Our Ref: FP/173/08/

Minor alteration to change roof detail over main entrance doors from hipped to gable detail & installation of new red fabric 4m square jumbrella

The Southdowns 133 Felpham Way Felpham

Thank you for your internet comments made on 29th September 2008 and recorded as follows:

Title
**PROPOSED ELEVATIONS, ROOF
PLAN AND SITE PLANS**

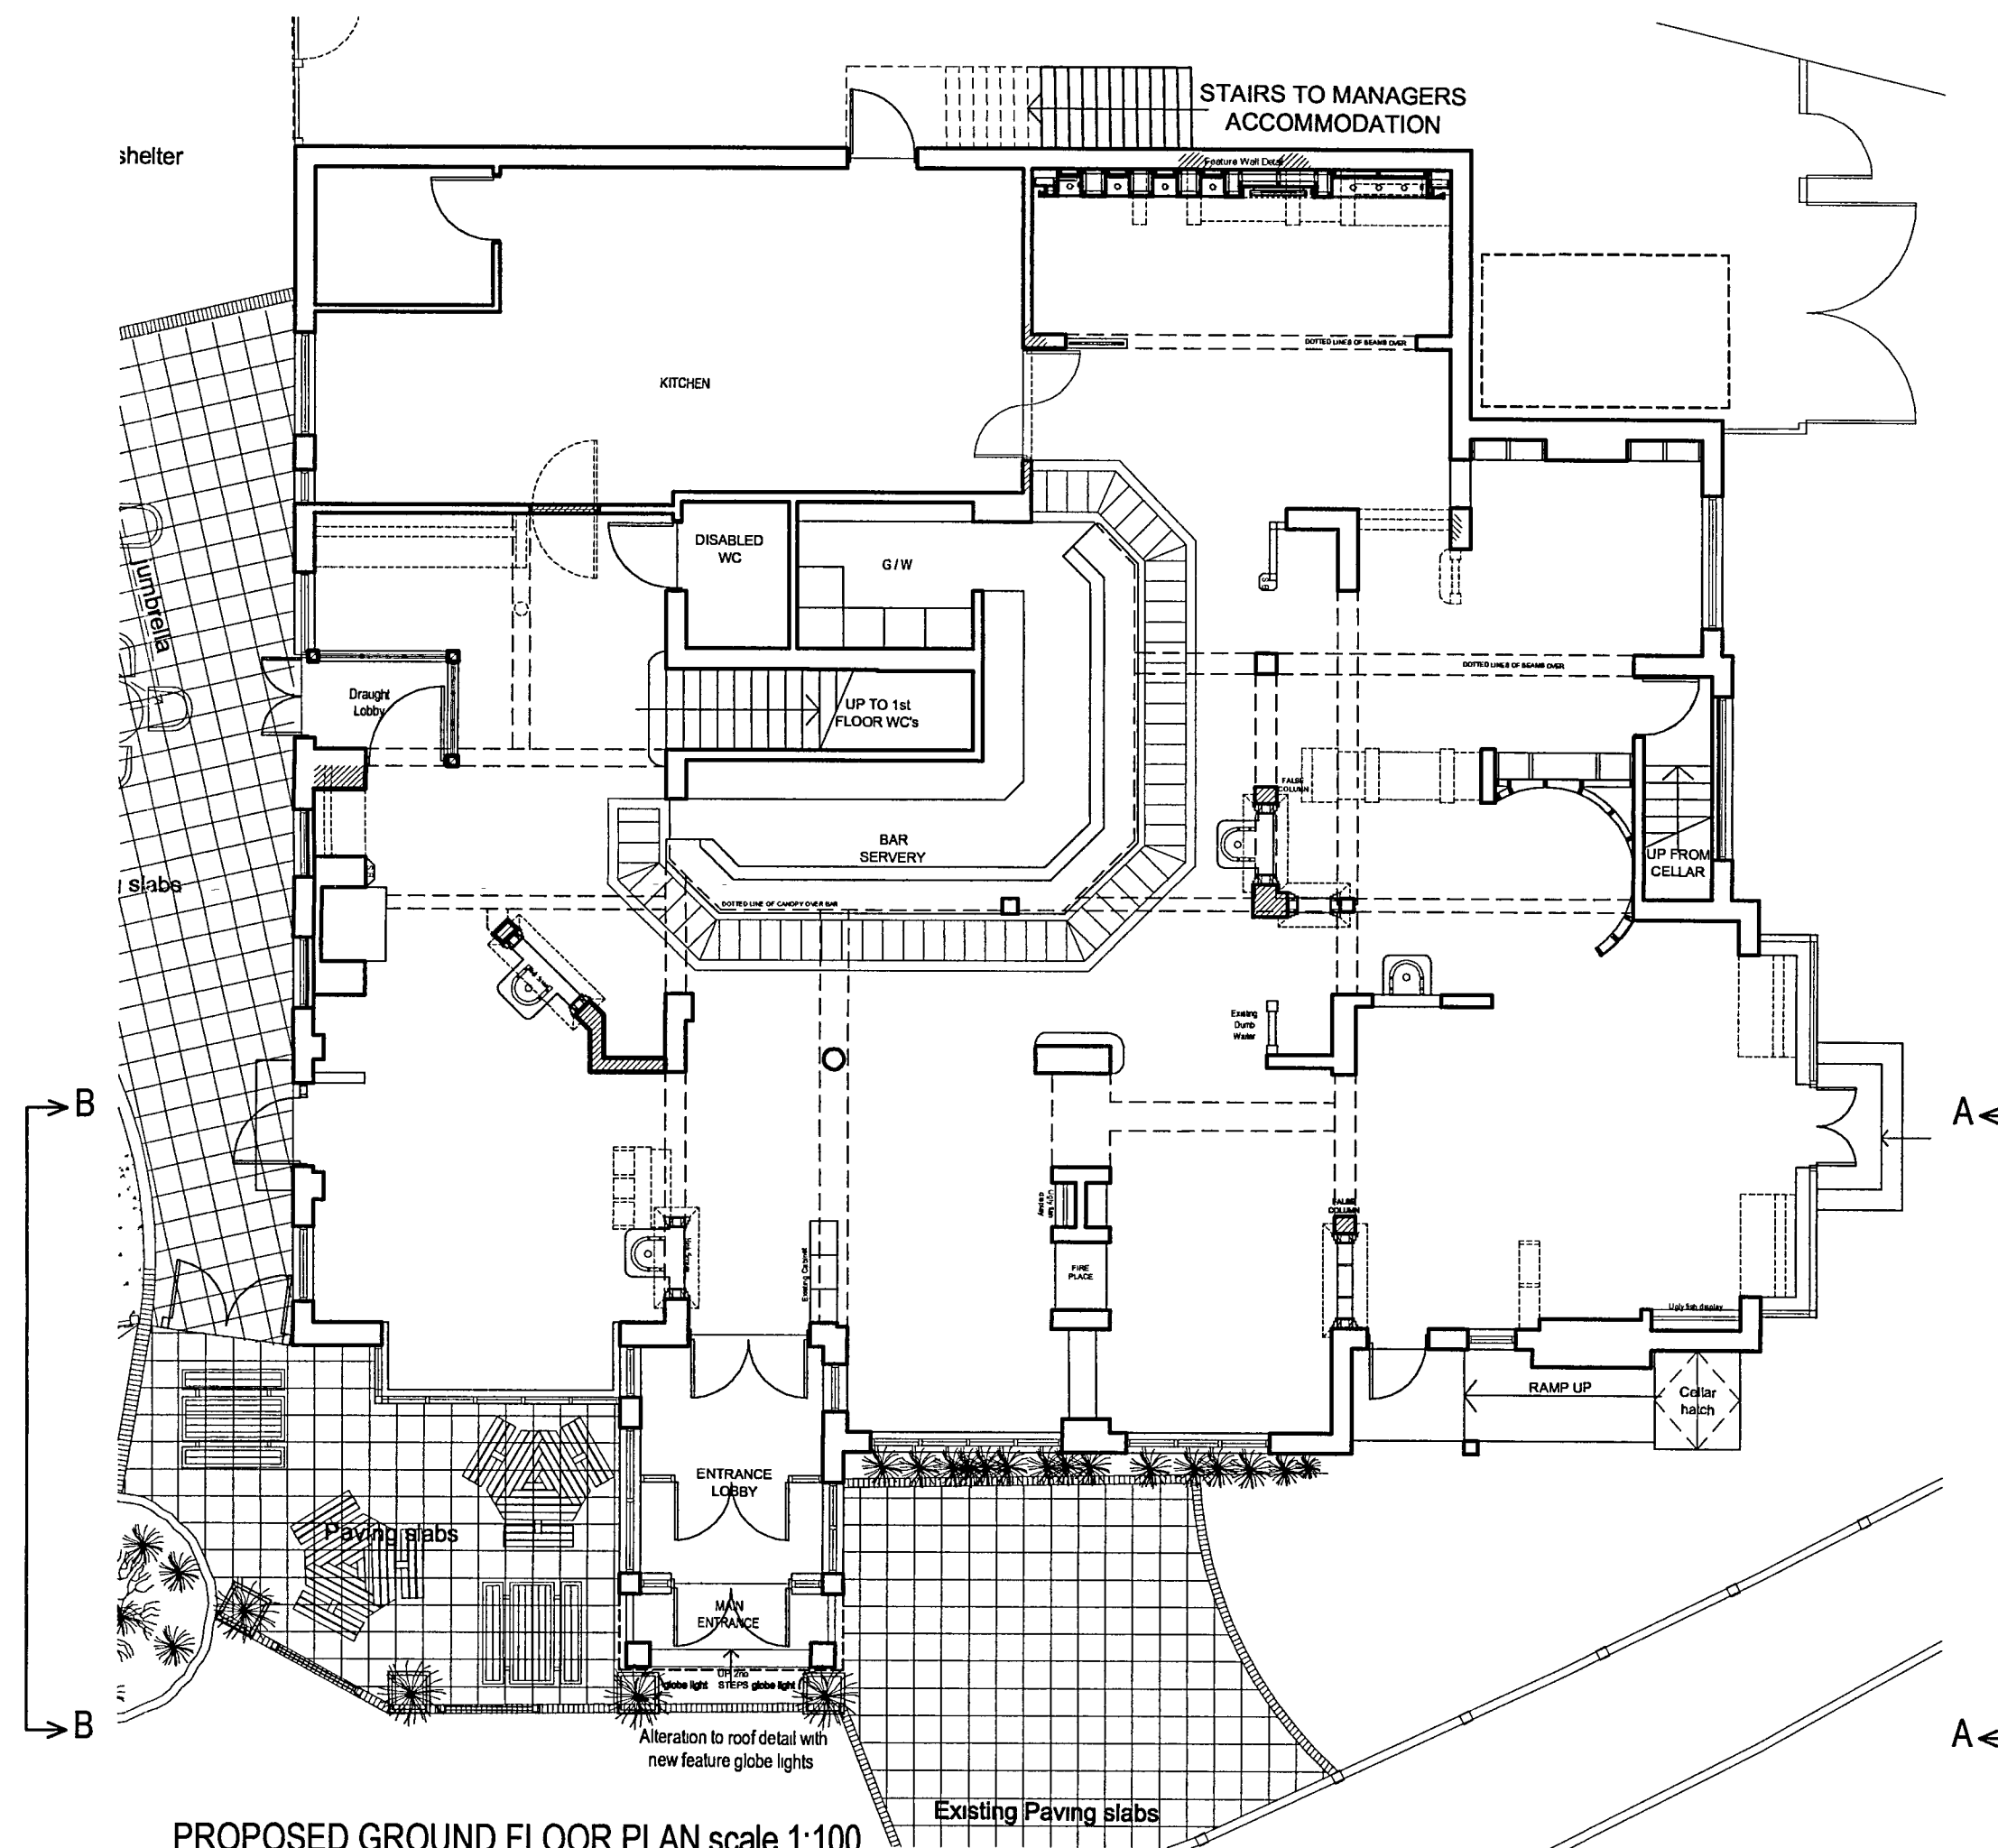
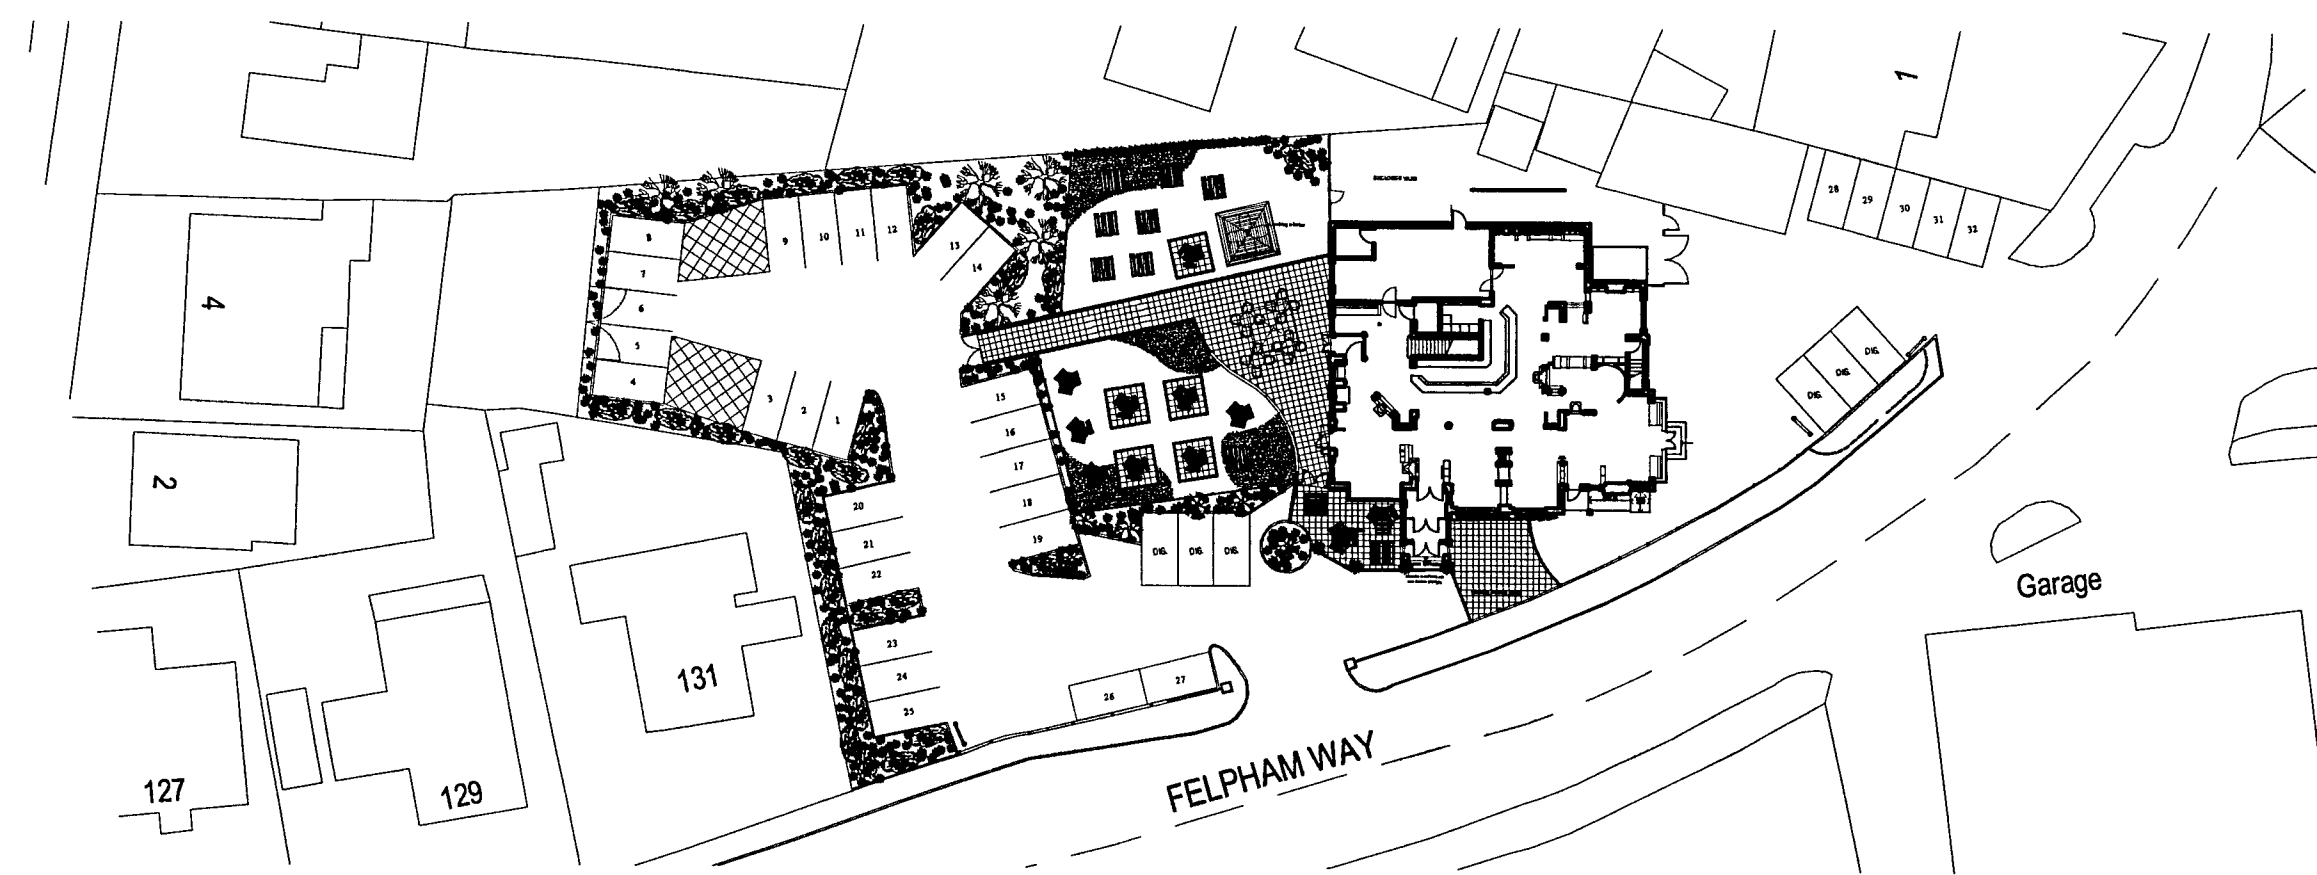
1. *The size and colour of the proposed Jumbrella will affect the visual amenity.*□
2. *The Jumbrella may be distracting to passing traffic where there is a Pelican crossing and a busy roundabout in the immediate vicinity causing a potential safety hazard to both pedestrians and motorists.*□
3. *The proposed site of the Jumbrella for external seating is not appropriate adjacent to such a busy road.*
